MONA OFFSHORE WIND PROJECT

Response to Martyn and Margaret Hussey D3 Submission

Application Reference: EN010137

Document Reference: S_D4_25

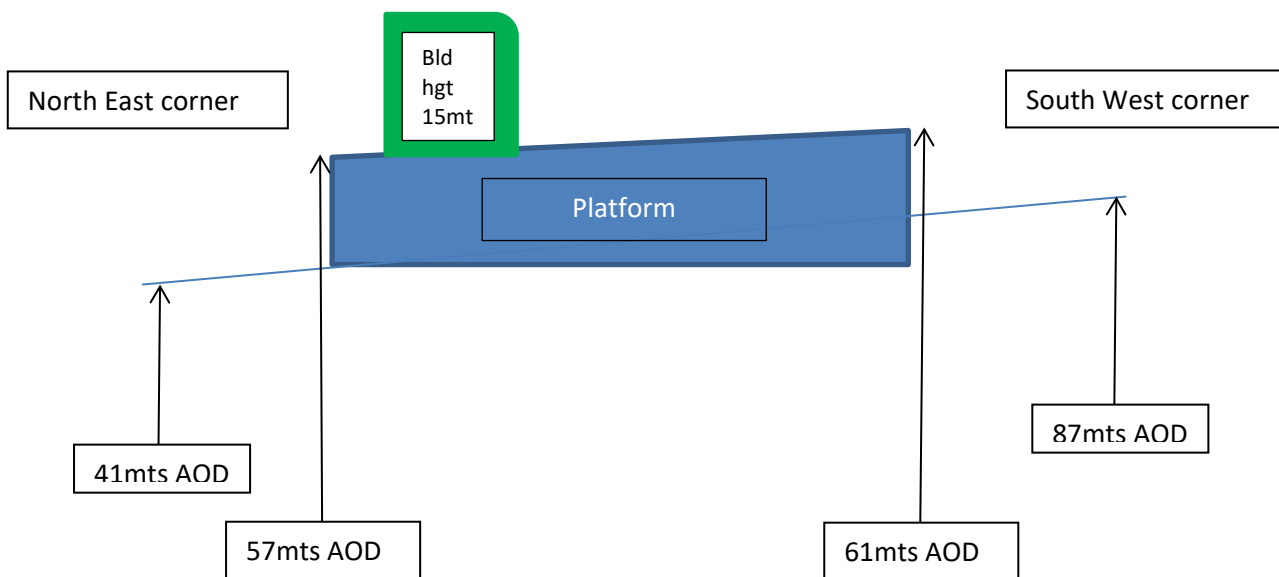
If the existing land is 41mts AOD at lowest point towards North Eastern corner and the platform slopes from 61mts to 57mts for hydrological reasons (drainage) and the lower height of the platform is assumed to be towards the North Eastern corner as indicative drawings show and information given to land users then:-

As stated above in REP3-110.24, the existing ground level low point of 41 m AOD is not located within the onshore substation platform itself, but rather to the area located north, within Work No 23.

The existing ground level low point within Work No. 22 (the onshore substation platform) is approximately 54 m AOD. The Applicant has provided indicative onshore substation cross-section figures (S_D4_25.1) to illustrate this. The information presented on the onshore substation cross-sections has been derived from LiDAR and topographical survey data and early construction feasibility work undertaken by the Applicant.

The finished ground level of the onshore substation platform is anticipated to be between 57 and 61 m AOD. The onshore substation buildings will be built on top of this, with a maximum height of 15 m. The lightning masts will also be built on top of the platform. The visualisations have been produced using these maximum design scenario parameters.
